**Job No:** 2023-4934  
**File Ref:** N01-SG-Response to Highways (231130)  
**Date:** 30<sup>th</sup> November 2023  
**Job Title:** Land to the rear of 726 Field End Road, Ruislip

**Subject:** Response to Highways Request for Information  
 Planning reference 77818/APP/2023/300

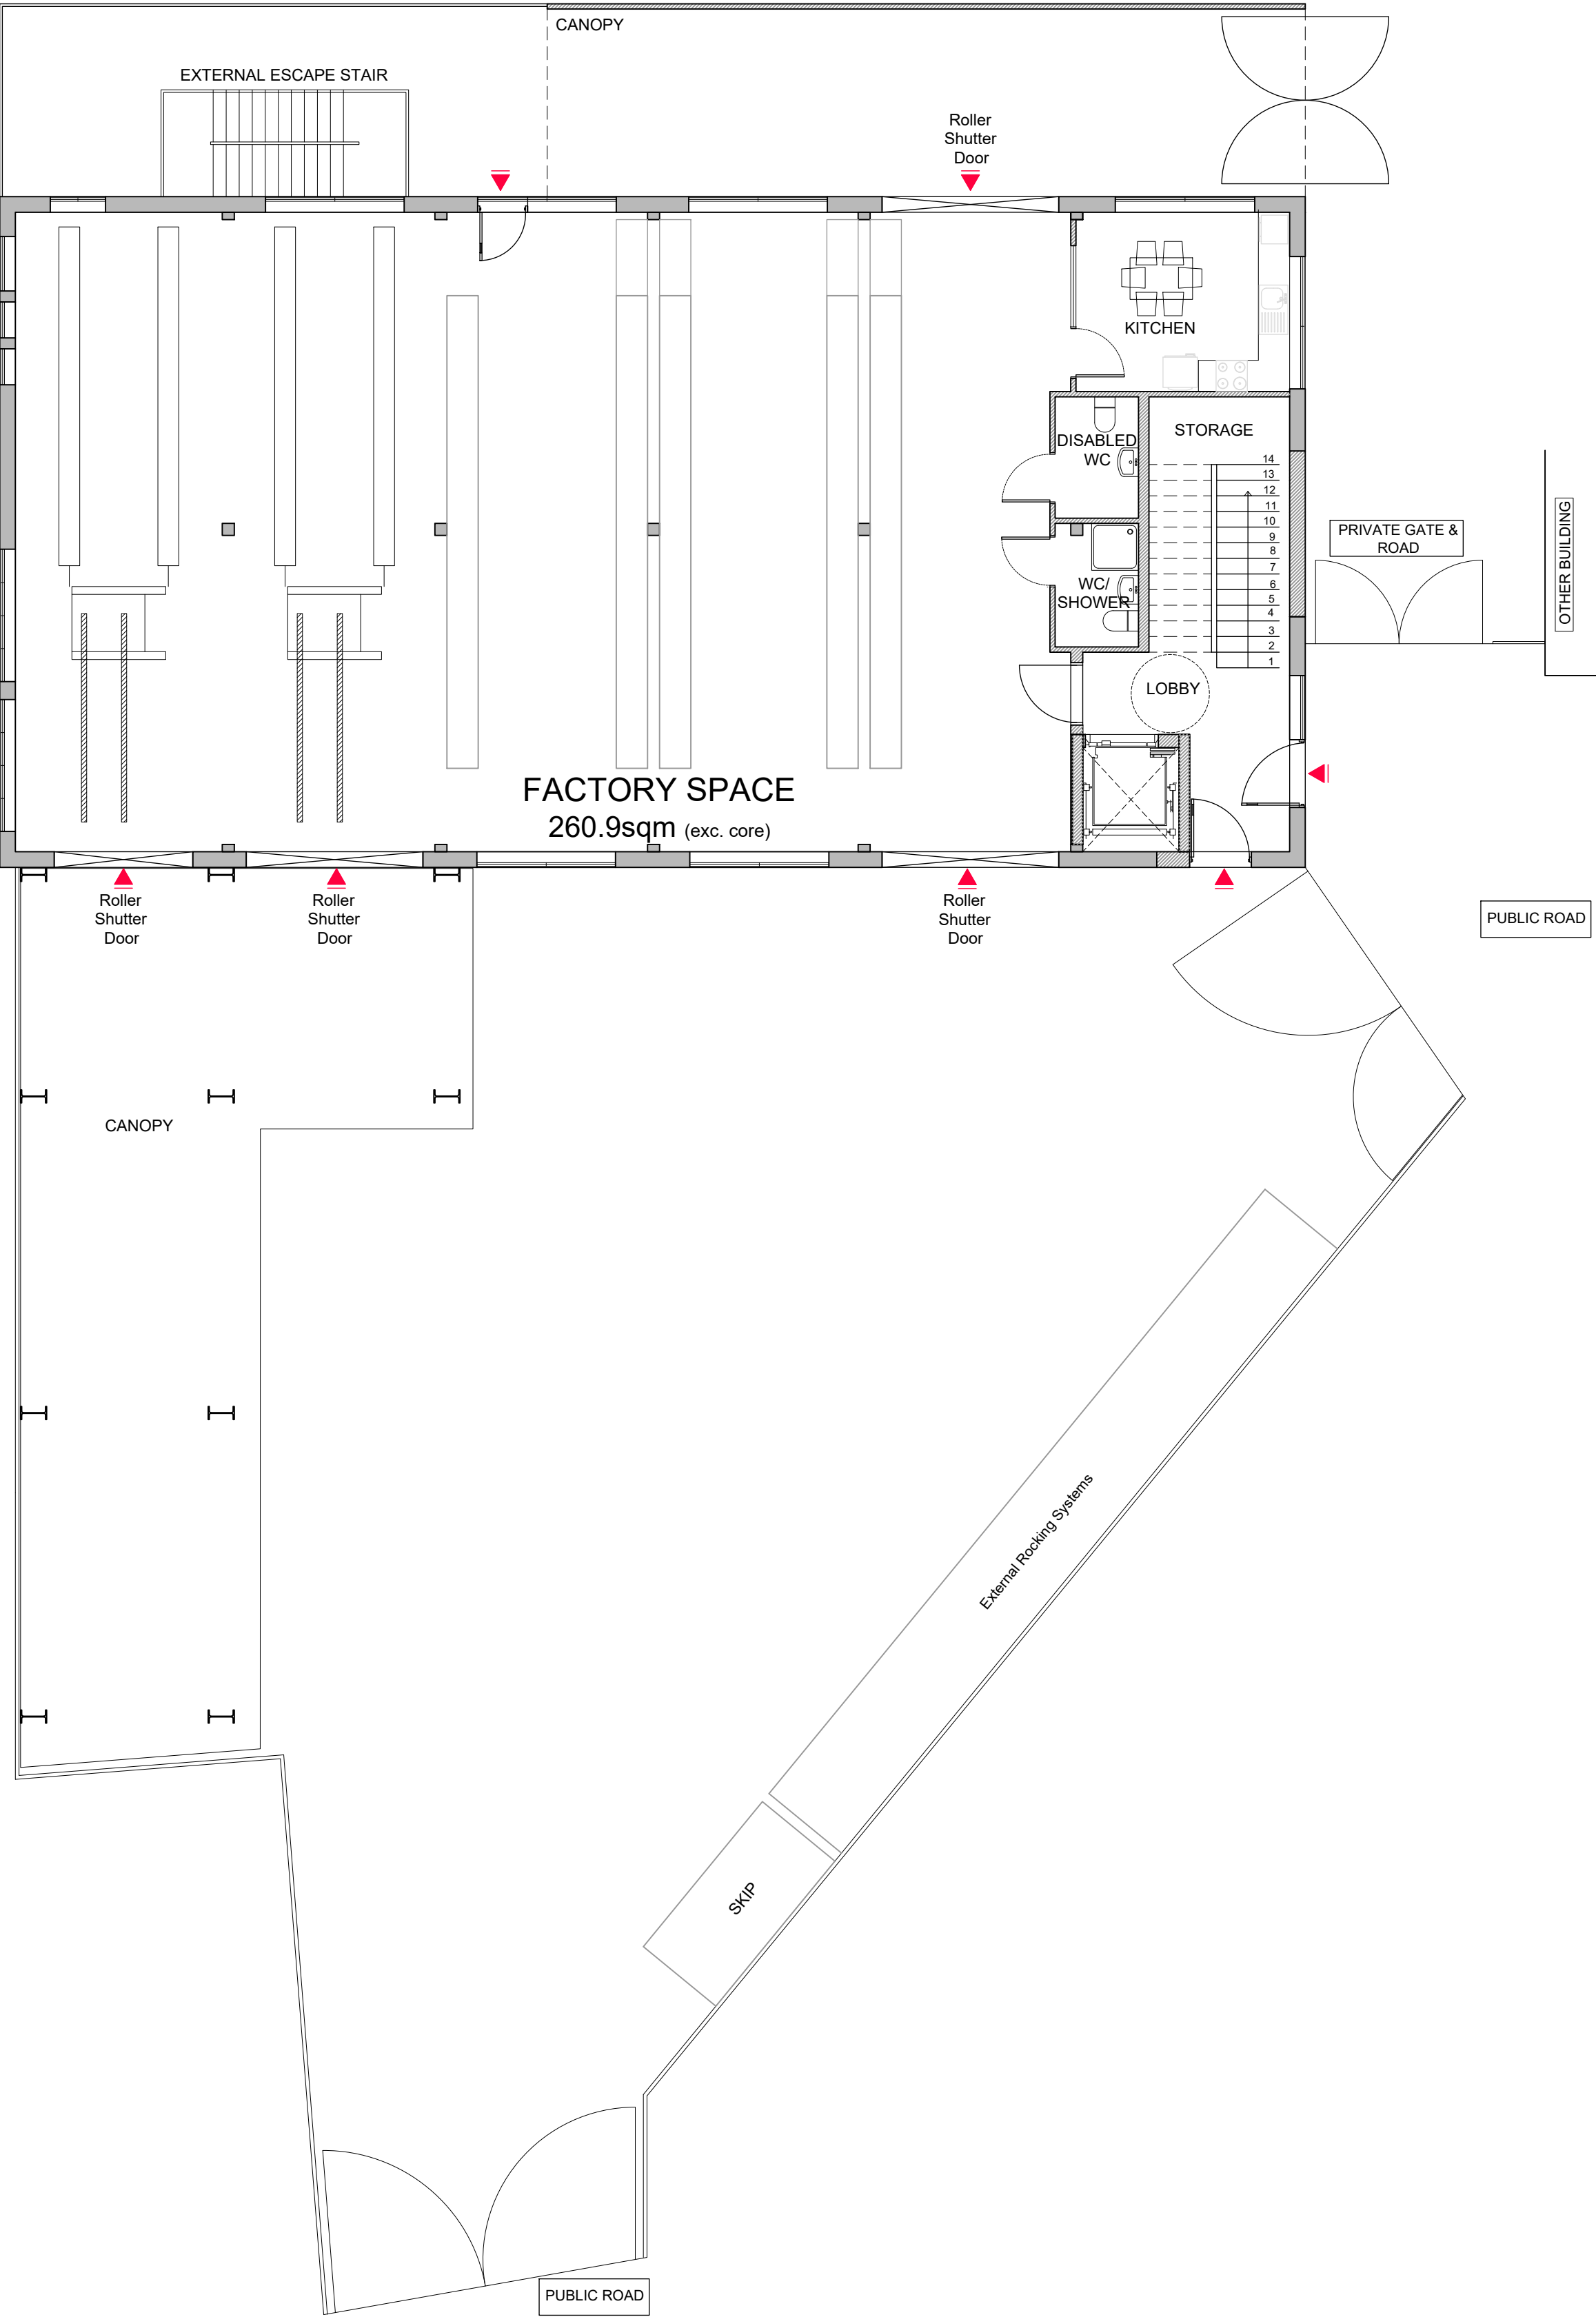
Several formally marked on-plot parking spaces are currently present but, it would appear that these would be deleted to facilitate the factory operation technically rendering the proposal as 'car-free'.

The maximum local parking standard for an E(g)(iii) use class would require in the region of up to 10 spaces and none are to be provided. 4 formal spaces are currently provided on-site which would be lost due to the reconfiguration of the envelope. This action could potentially encourage some undue parking displacement onto the unrestricted roadways in proximity of the address such as 'Brackenhill' to the south (designated as social housing land).

Unfortunately, the applicant has not presented an assessment of likely parking demand (and spare on street parking capacity (if any)) or general daily activity generated by the factory proposal. Without such information, the Highway Authority cannot make an informed decision on the acceptability (or otherwise) of the proposal (see conclusion).

In terms of cycle parking, there would be a requirement to provide 4 secure and accessible spaces for the proposal. **Although not depicted, this aspect can be secured via condition.**

13. It is proposed that eight parking spaces will be provided to serve the site at Field End Road. Of these, two will be provided with electric vehicle charging points and one will be accessible.

16. The highways response notes that cycle parking is not shown on the submitted plans and allows that this can be secured by condition. It is proposed that cycle parking will be provided in the yard to the rear of the building. The cycle parking will be sheltered and secure. The proposals include the provision of showers and changing facilities which will be available for use by cyclists.
